Your Ref: OWPC6018
Our Ref: K/17/15/HH 06-05-2015
Please ask for:
Ross Leal

2 Storey side & rear extensions with balconies, conversion of roof void to create En-suite Bedrooms including the insertion of 3no. new dormers, roof alterations, new Garage outbuilding with ancillary accommodation & link to main house & swimming pool.

Russet House Gorse Avenue Kingston Gorse Kingston

Thank you for your internet representation made on 12th June 2015 which has been recorded as '**an objection**' with the comments as follows:

Second Floor Plan

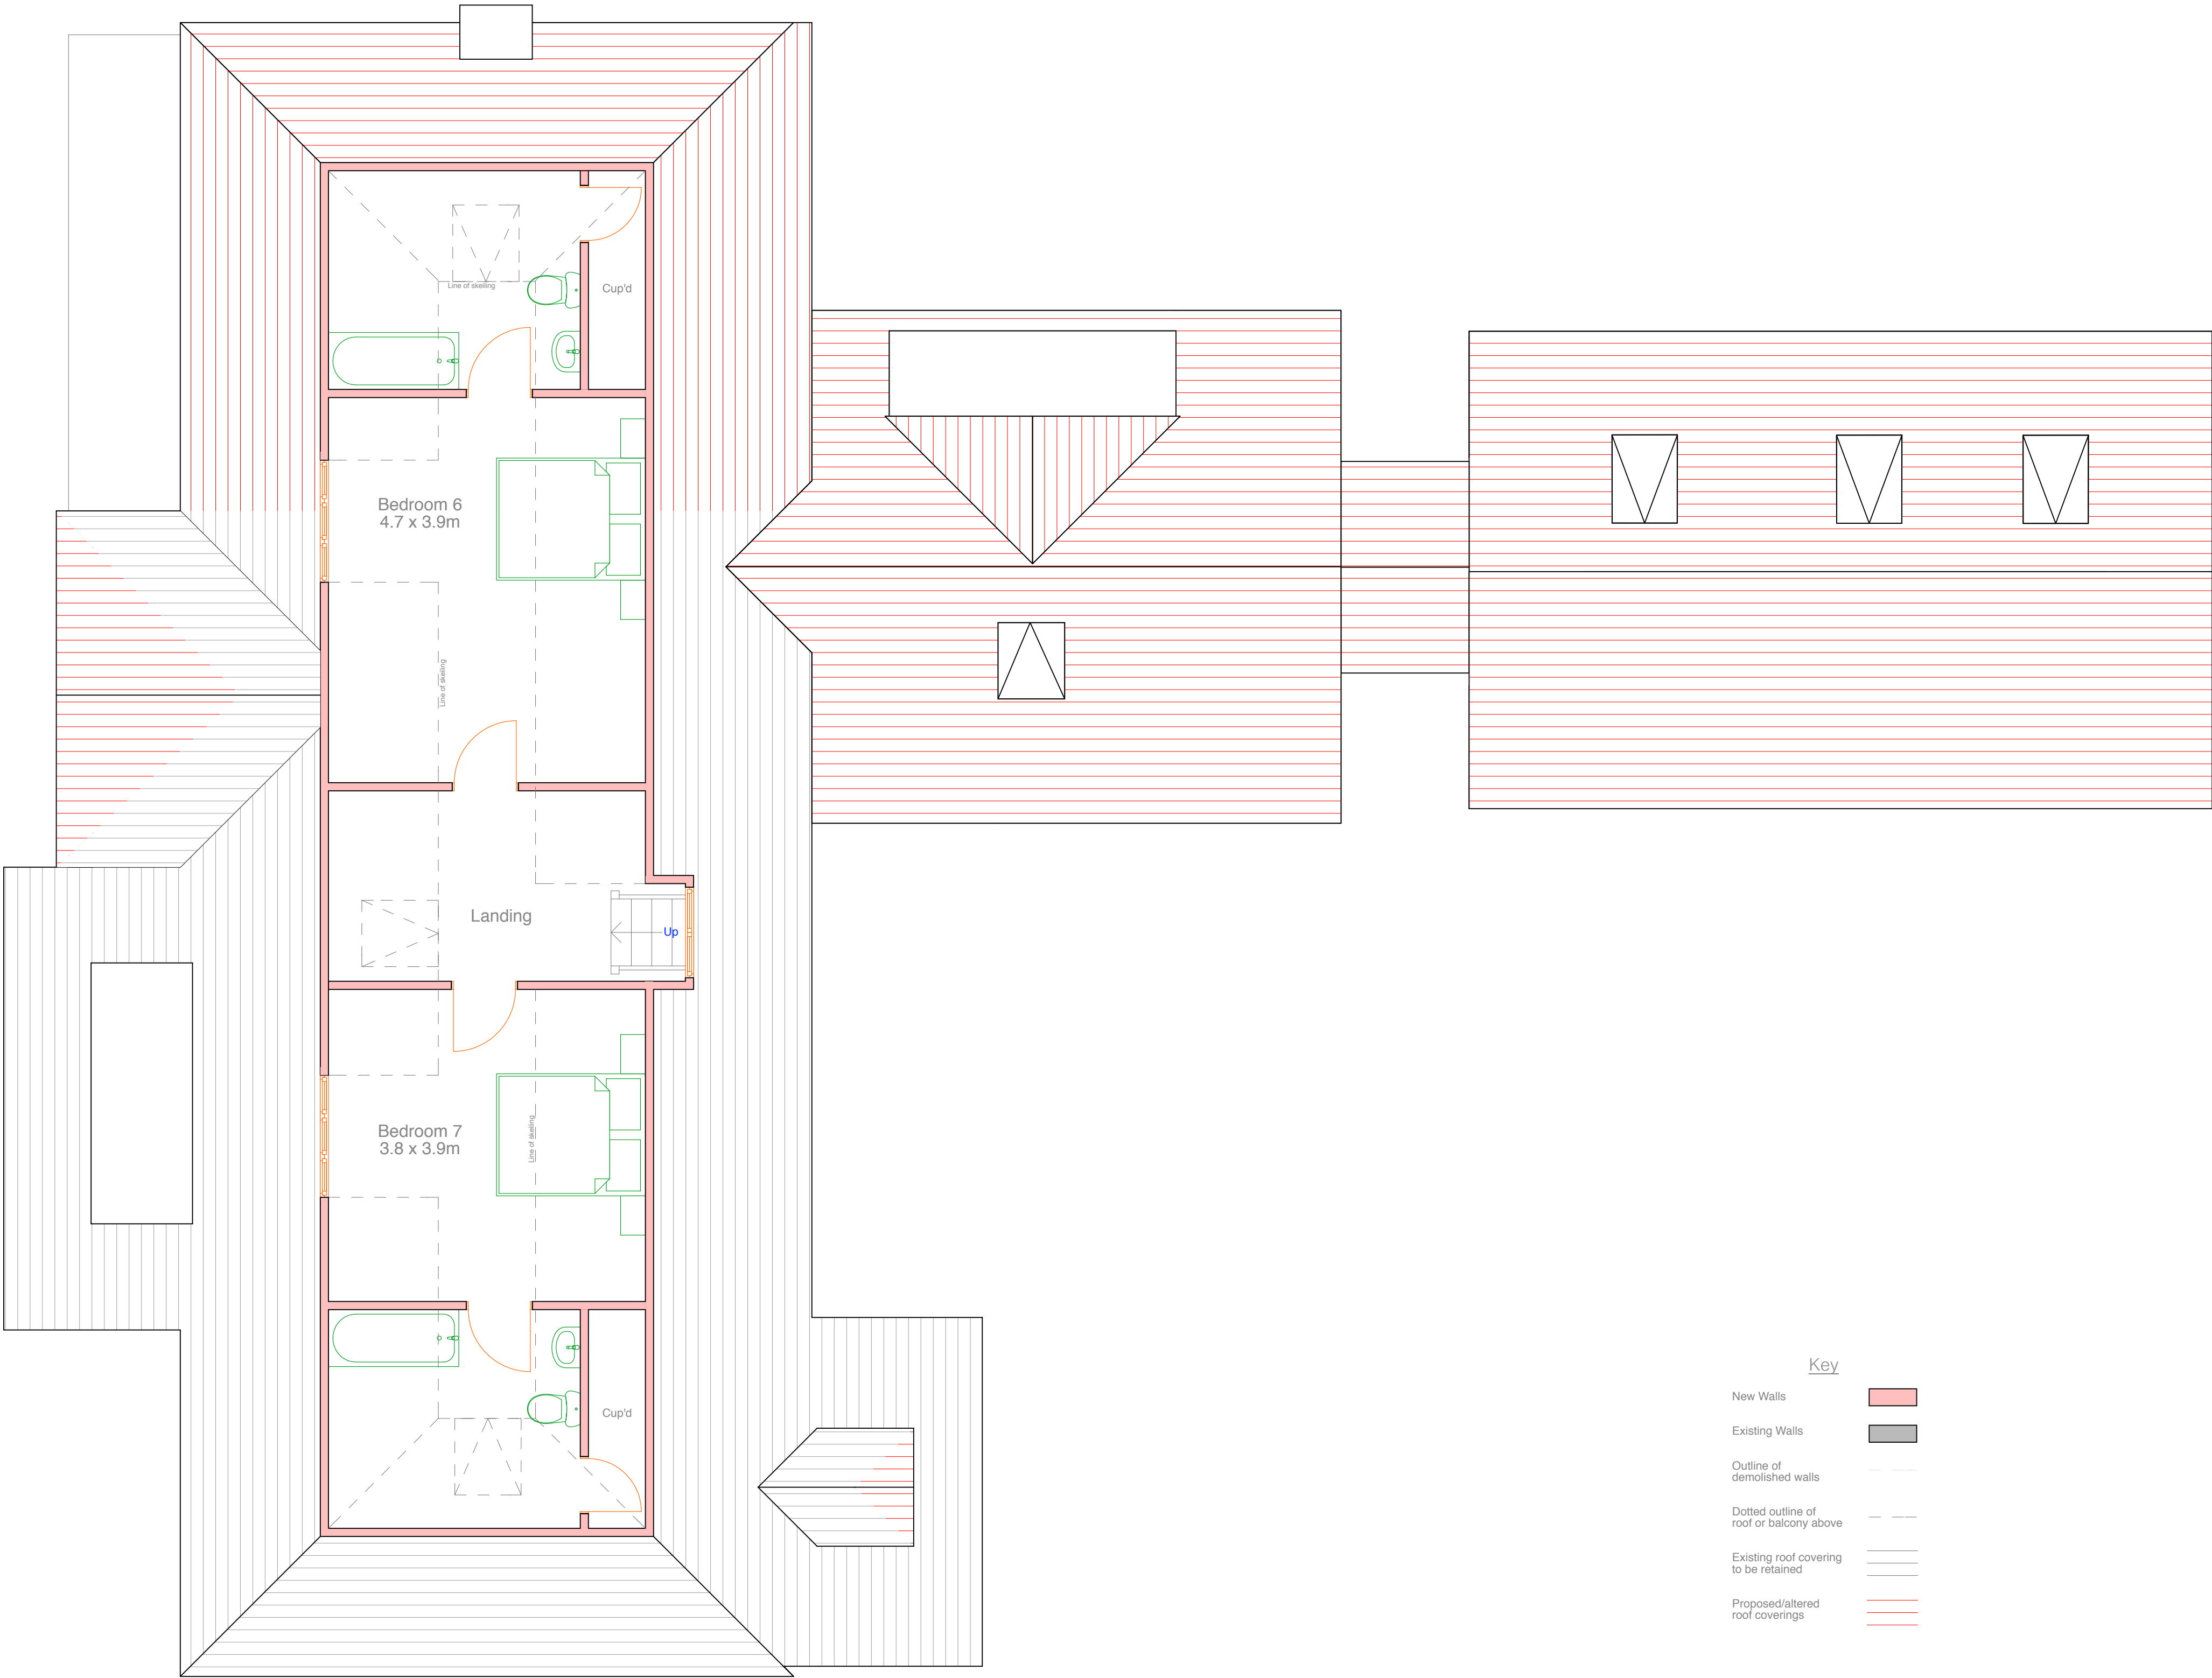
The proposed dormer windows and skylight would add a third storey to the southern aspect of the applicants' house which would therefore overlook our home which has only two storeys. This would compromise our privacy as we have many windows on the ground and first floors all at a lower level to the proposed dormers and skylight windows.
